Lime Down Solar Project — Open Floor Hearing 1

21 April 2026 • Danny Pike, Secretary, CAWS (speaking also for Melksham Without Parish Council)

Application Doc no.:EN010168/APP.6.2

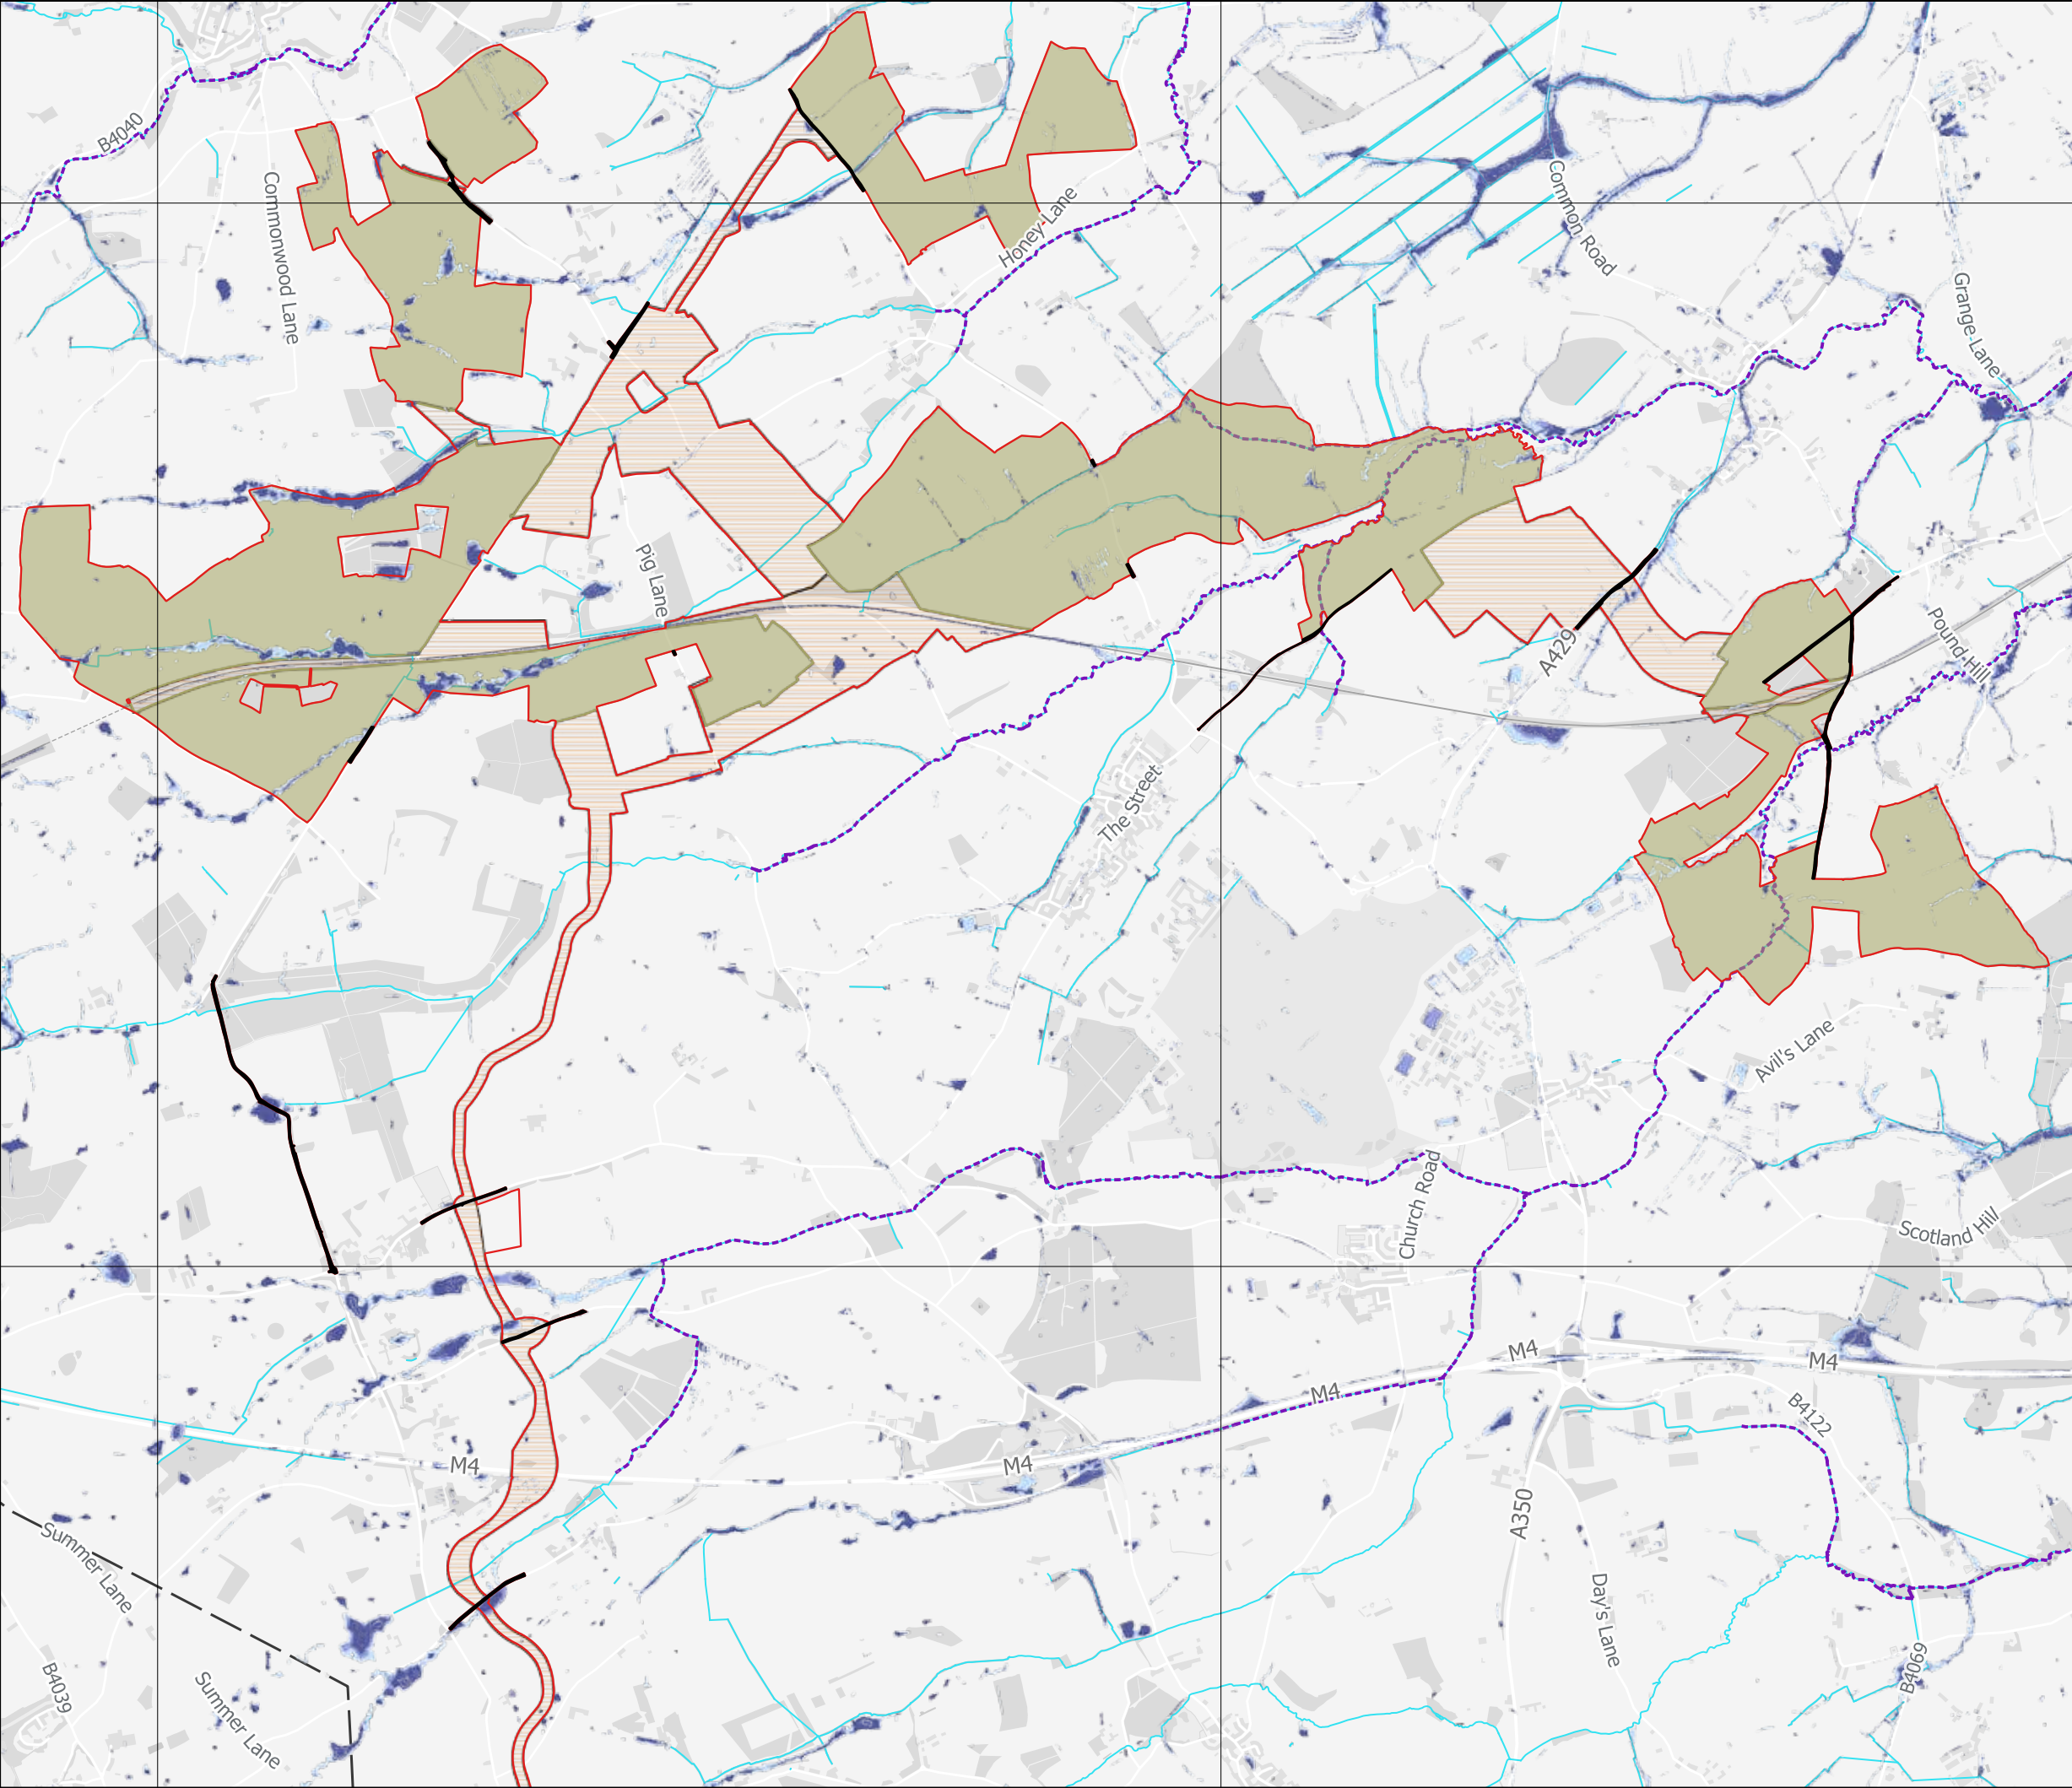
Whitley and Shaw are two small villages that sit at the foot of a dense headwater catchment. When several headwaters are disturbed during construction, the flow downstream includes both sediment and contaminants moving through connected drainage, and into the wider river basin. The effects are cumulative, yet that catchment has not been assessed as a catchment by the Applicant.

Title:
Figure 13-12 Construction Access Locations:
Cable Route Corridor

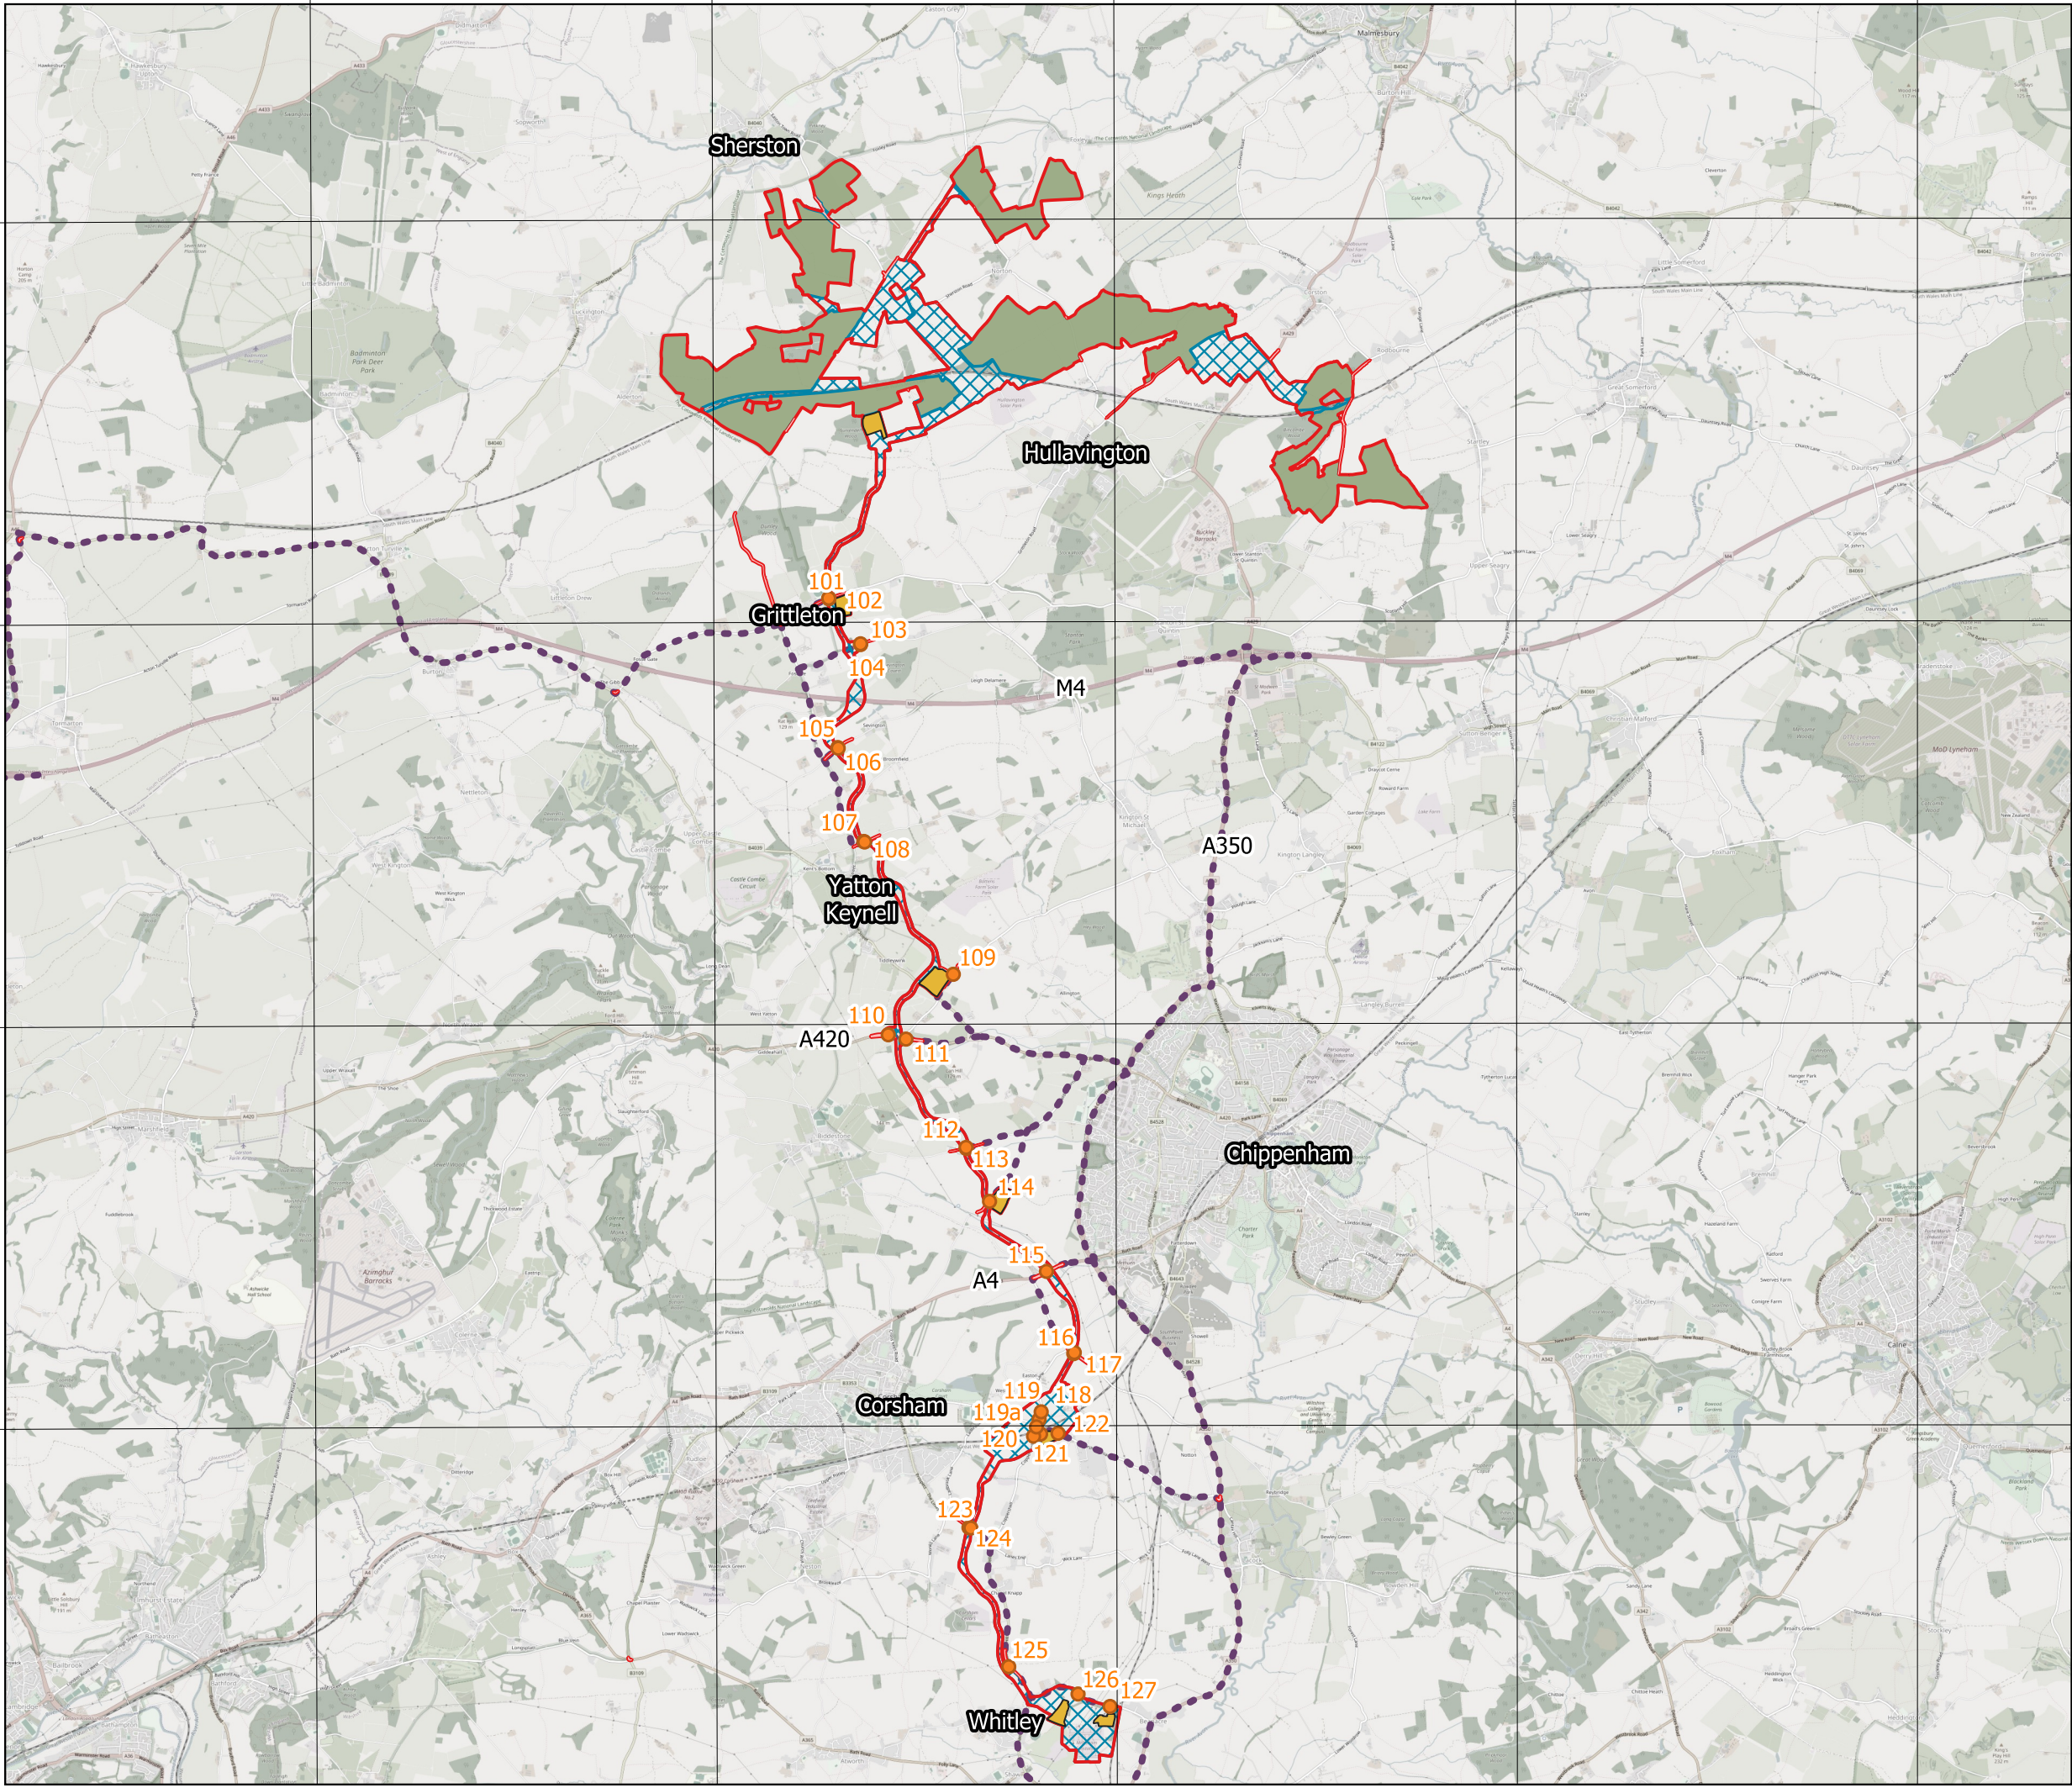
The proposed cable route has a wide working corridor, stretching from north of the M4 over fields, roads, a railway and on to Melksham Substation. The Applicant asks us to accept that they will manage the project, but they do not define their construction methods in detail. Key elements of how it will be built are deferred to later stages, so the consequences cannot be predicted. Deferral does not remove risk; it is an attempt to avoid taking responsibility for it.

Title:
Figure 21-2: Location of Cumulative Solar Infrastructure in Proximity to Lime Down Index

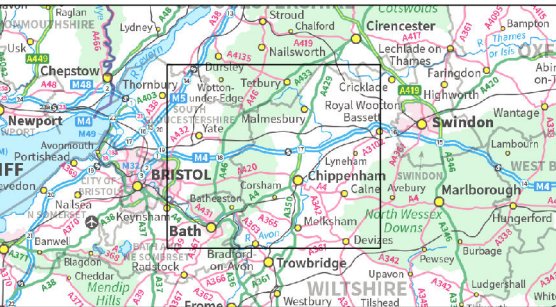
The Applicant contends that the cumulative impacts from their project have been assessed. Our position is that the material that they have presented to you is inadequate. In particular, their Environmental Statement assesses the impacts

as if it were the only project in the area. But it is not. And the risks of all of these projects are cumulative, and capacity-limited.

Across the eighty schemes in our area, battery storage is a repeating feature. The assessment of those schemes is site-by-site; yet the risk is not. They all depend on a shared Fire and Rescue response. Yet, there is no cumulative

major-accident assessment for all these projects, and no clear evidence that Wiltshire Fire and Rescue has been asked to consider one.
